January 24, 1996

RE: Bear Canyon Compound - Grading Certification

RE: ENGINEER CERTIFICATION FOR BEAR CANYON COMPOUND  
FINANCIAL GUARANTEE RELEASE (F19-D32) CERTIFICATION  
STATEMENT DATED 1/24/96.

SHEET TITLE:
CONCEPTUAL GRADING AND DRAINAGE PLAN
 Project Manager: **DWG**
 Drawn By: **RBR**
 Project No.: **PH**

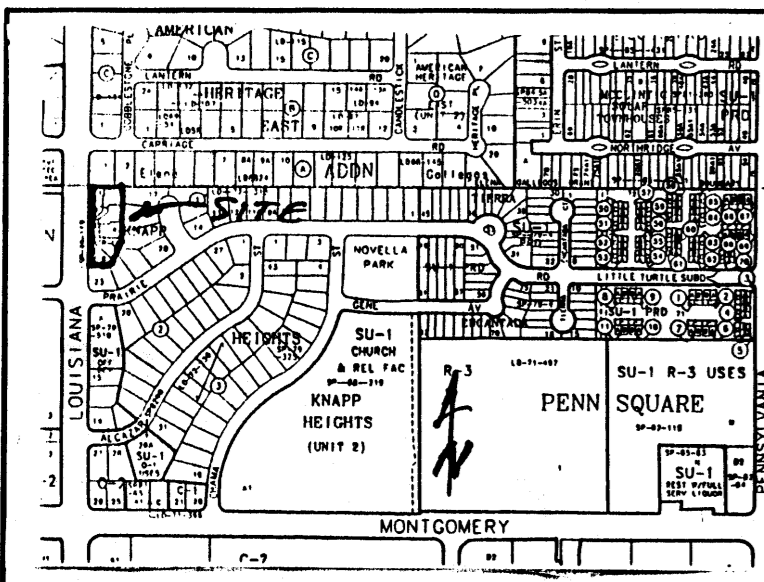
1. The existing contours shown indicate that offsite flows from the east impact the site. Neither your plan or calculations indicate how you propose to handle these flows.
2. Please describe downstream drainage conditions as far as existing improvements and whether there has been flooding in the past.

GRADING & DRAINAGE PLAN

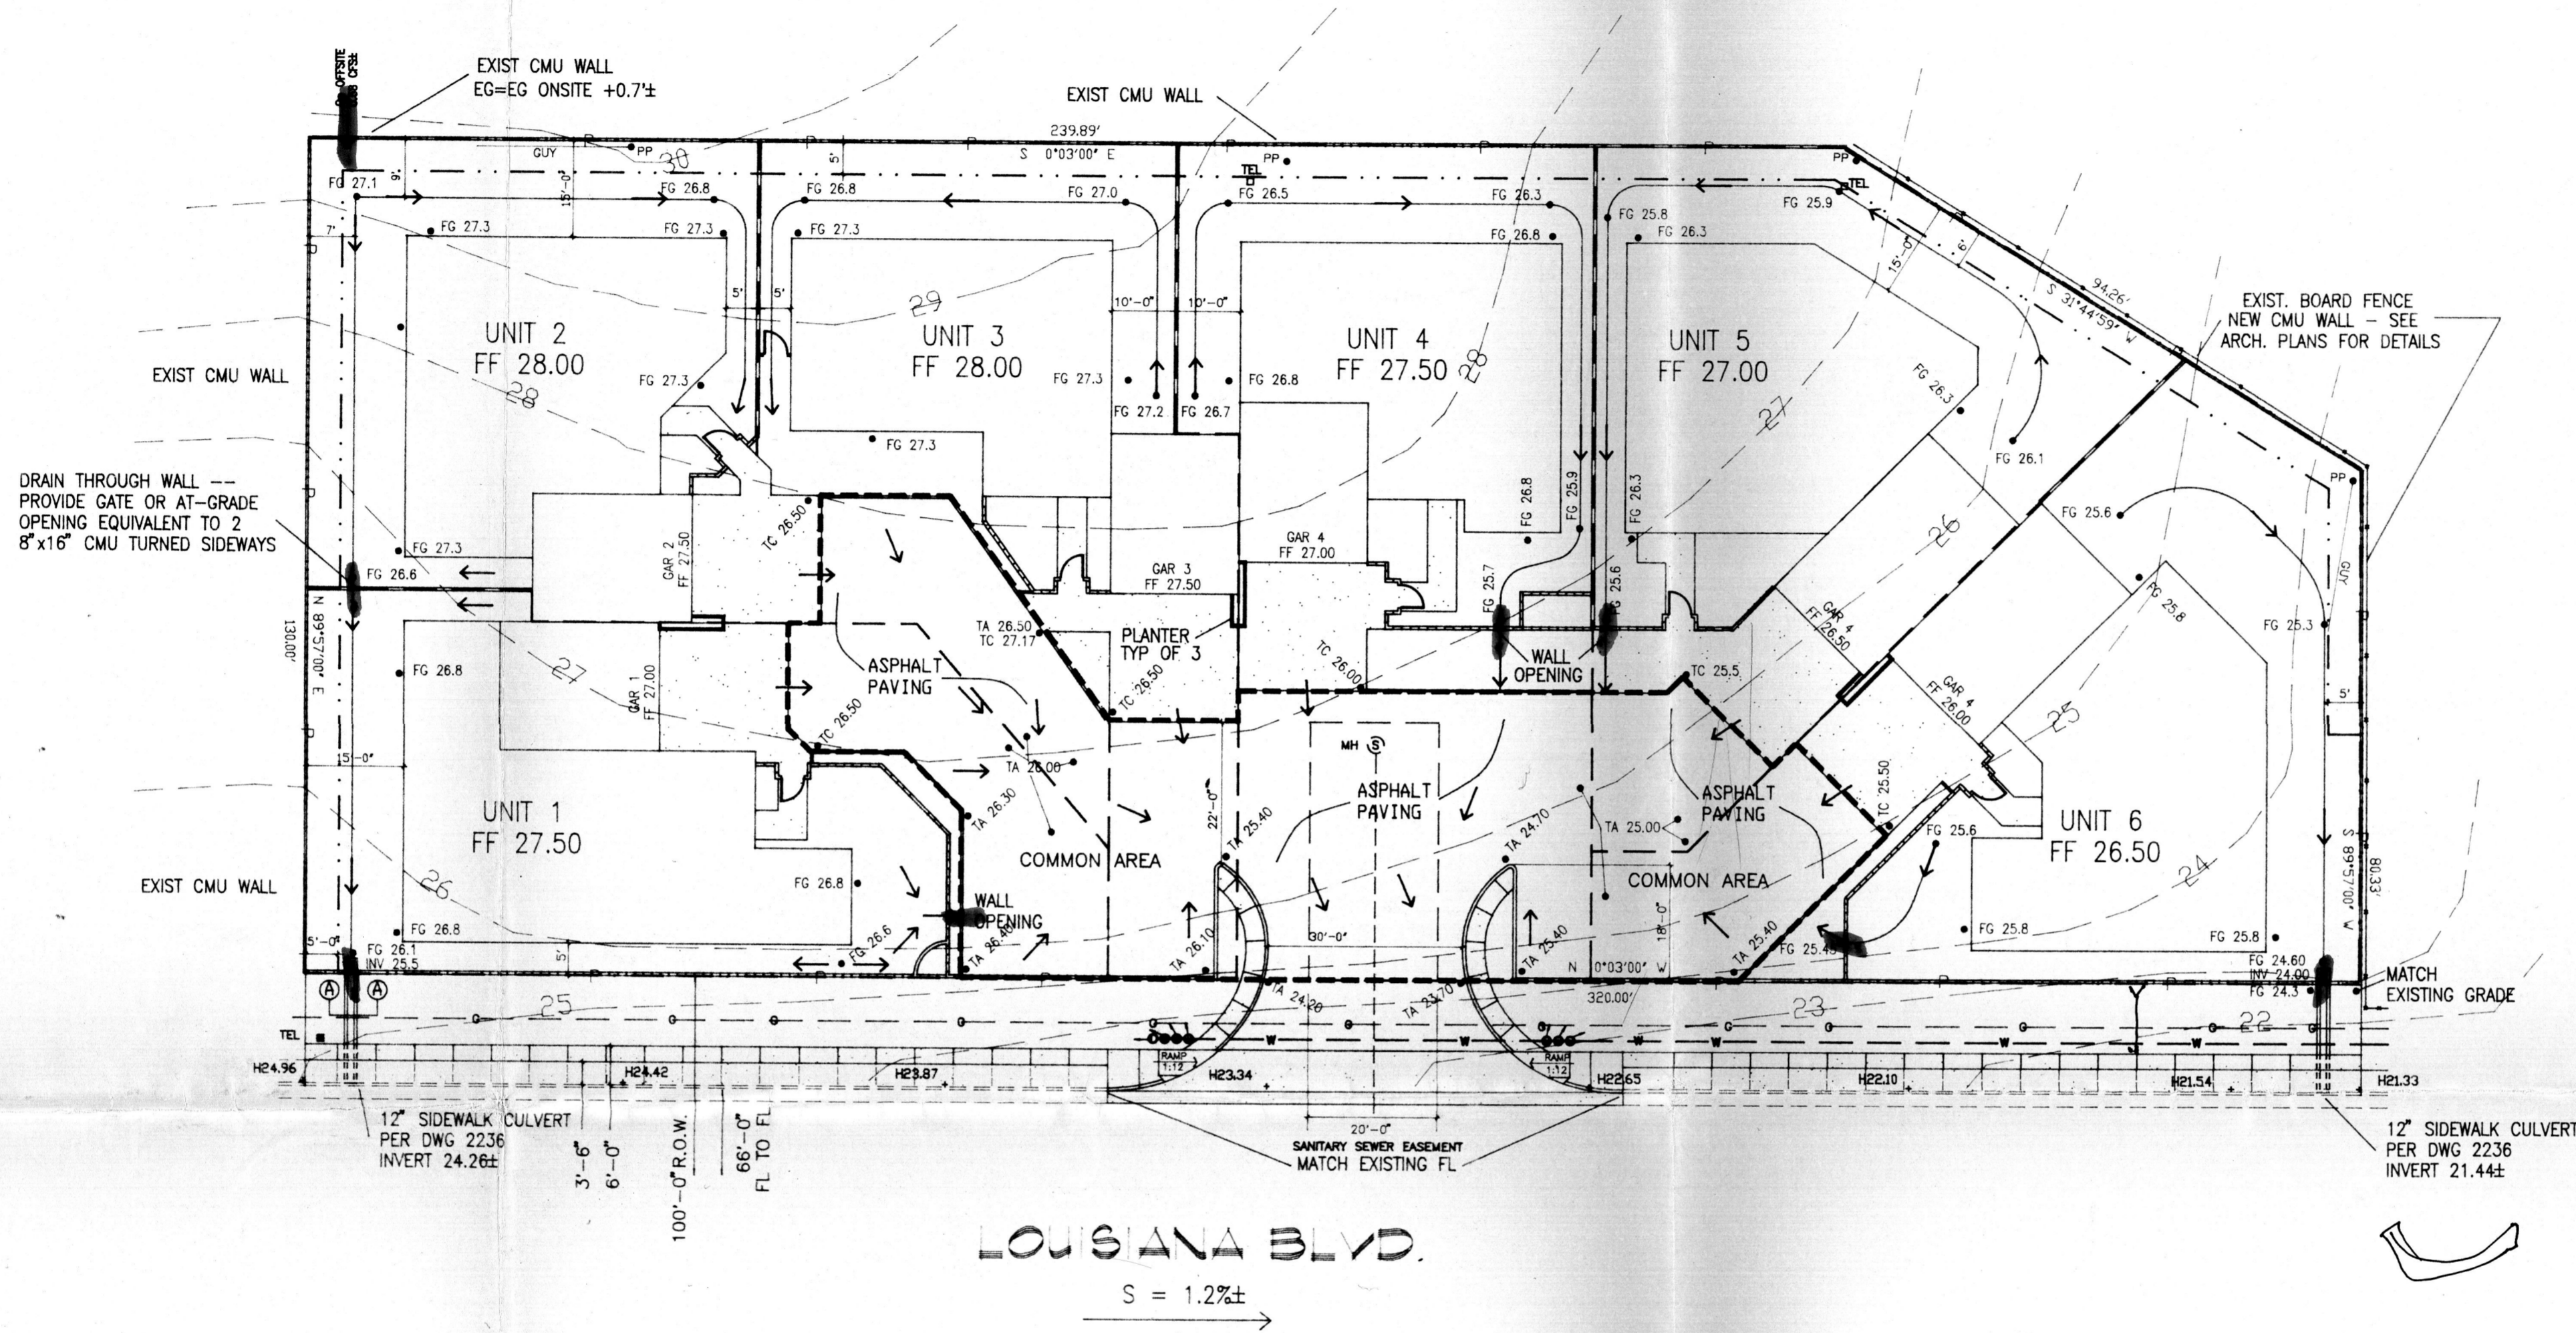
The purpose of this letter is to request a design variance which would allow a small portion of roof drainage, from Unit 5 of the referenced subdivision, to pond in the backyard of that unit. See final grading certification stamped January 20, 1996 for hydrology calculations and final as built grades.

The reason for this request results from the builder/developer's decision, during construction, to change the City approved grading of Unit 5. It was the builder/developer's idea to drain the backyard of Unit 5 across the rear yard of Unit 6 via a private drainage easement. At the time the builder owned Unit 6 and therefore did not anticipate a problem with the easement or the drainage concept. The builder sold Unit 6, however, without securing the granting of the private easement. Subsequently, the acquisition of the easement became most difficult. Therefore, it became necessary to come up with an alternative plan that would not require the easement.

The resulting plan is that shown which basically utilizes roof drains to convey roof water to a point which allows the discharge of water to the front yards. Unfortunately, a small portion of the roof (290 sf.) Could not be guttered without detrimental architectural problems. (See attached letter from architect).

- the eastern gutters should be reversed to flow water to the north, thus relieving the water to drain around the house.
- to relieve drainage water from the garage roof a gutter system would have to be built across the stucco portion of the eave above the southern windows. This would be a non-acceptable solution due to the eventual destruction of the stucco at the location of the gutter and the esthetics involved from the owners standpoint.

Based on the information provided on your January 24, 1996 resubmittal, Engineer Certification for Financial Guarantee release is acceptable. Also, your request for the design variance is granted because of the provided documentation.
